From: [Kelly Bacon \(CD\)](#)
To: [Chris Cruse; "dstanavich@gmail.com"](#)
Subject: RE: LP-21-00003 Stanavich - Transmittal of Comments
Date: Wednesday, November 10, 2021 1:29:04 PM

Subject: LP-21-00003 Stanavich - Transmittal of Comments

STANAVICH AG PLAT  
PART OF SECTION 35, T. 19 N., R. 18 E., W.M.  
KITITAS COUNTY, WASHINGTON  
- PRELIMINARY PLAT -

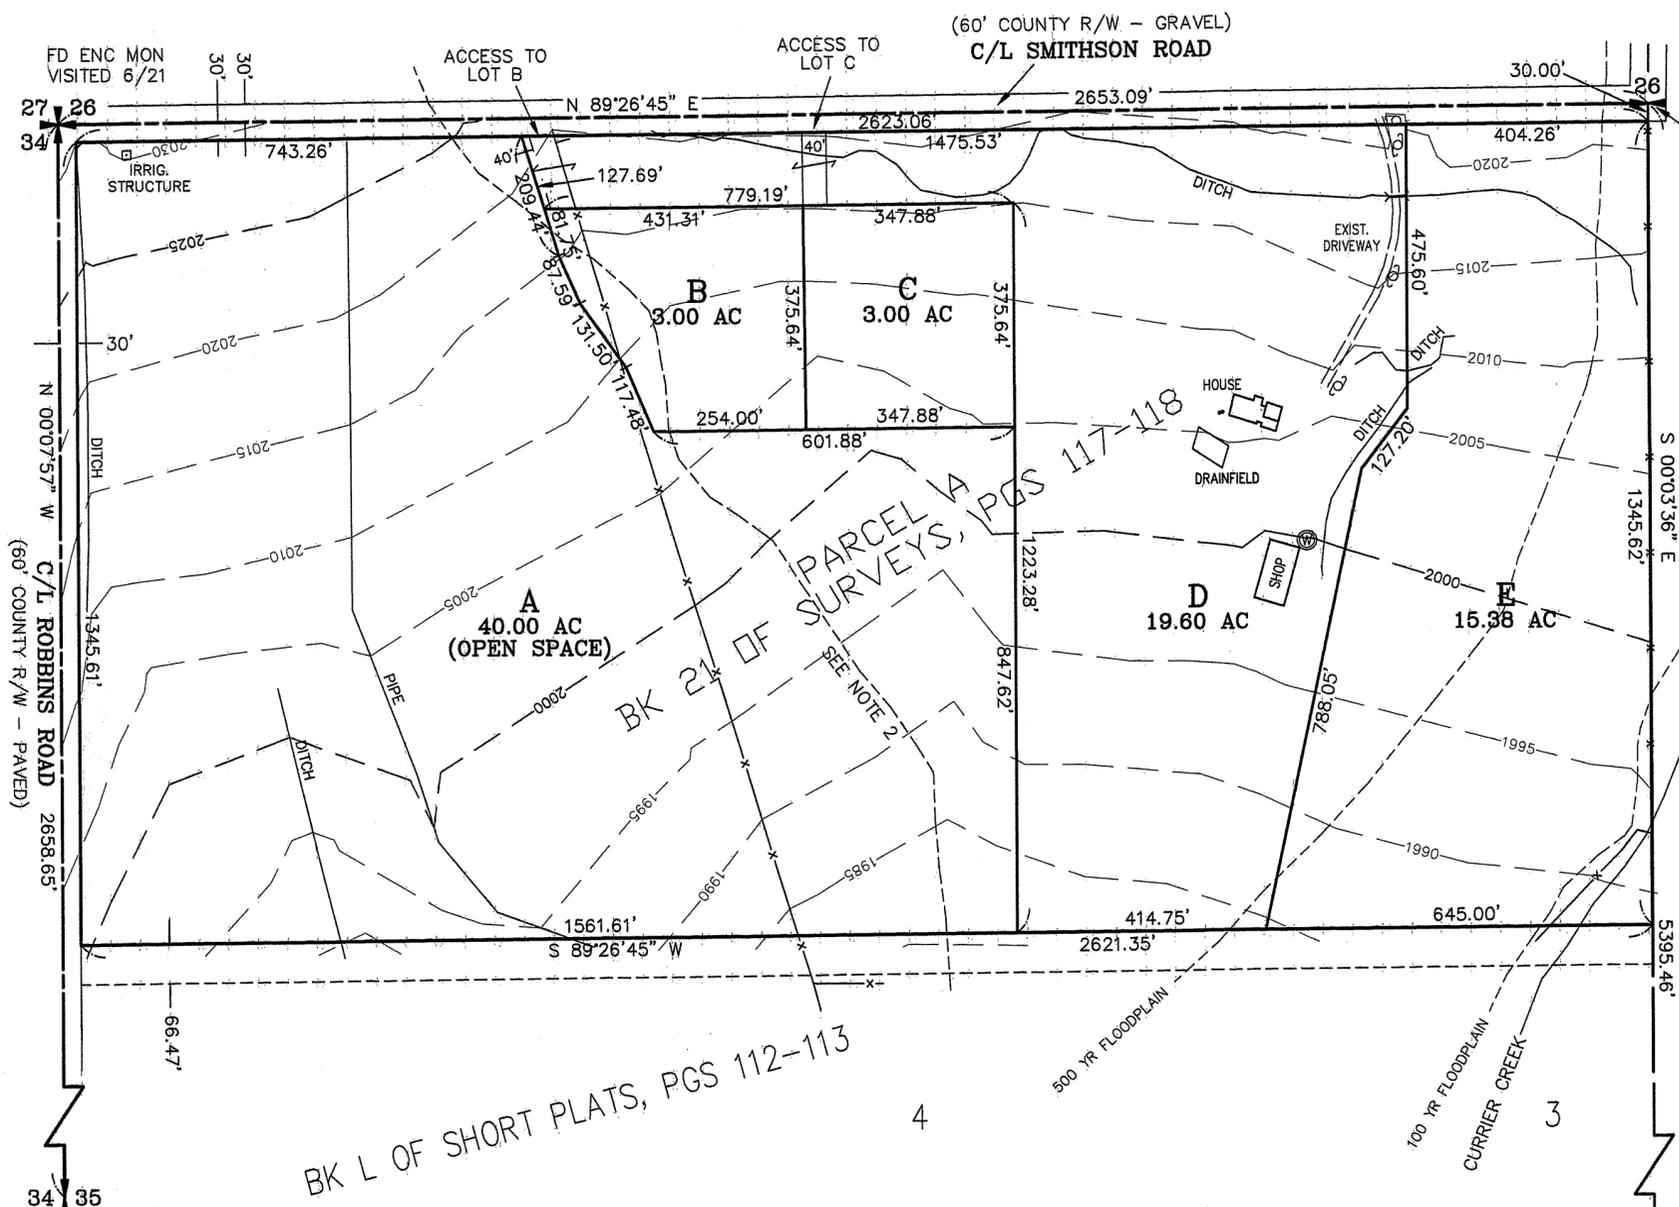
1. To limit the number of accesses onto the county road system, the plat must serve lots B&C and D&E from joint-use driveways. Direct access from an individual lot to the County Road shall not be permitted unless no other alternative exists. Newly created lots shall access onto an internal road system and not directly onto a County Road, unless approved by the County Engineer. Lots adjoining County Roads shall access from the lowest classified road or from a joint-use driveway, when possible. Police, fire, ambulance, and other emergency stations shall have a right to direct access to County roads.
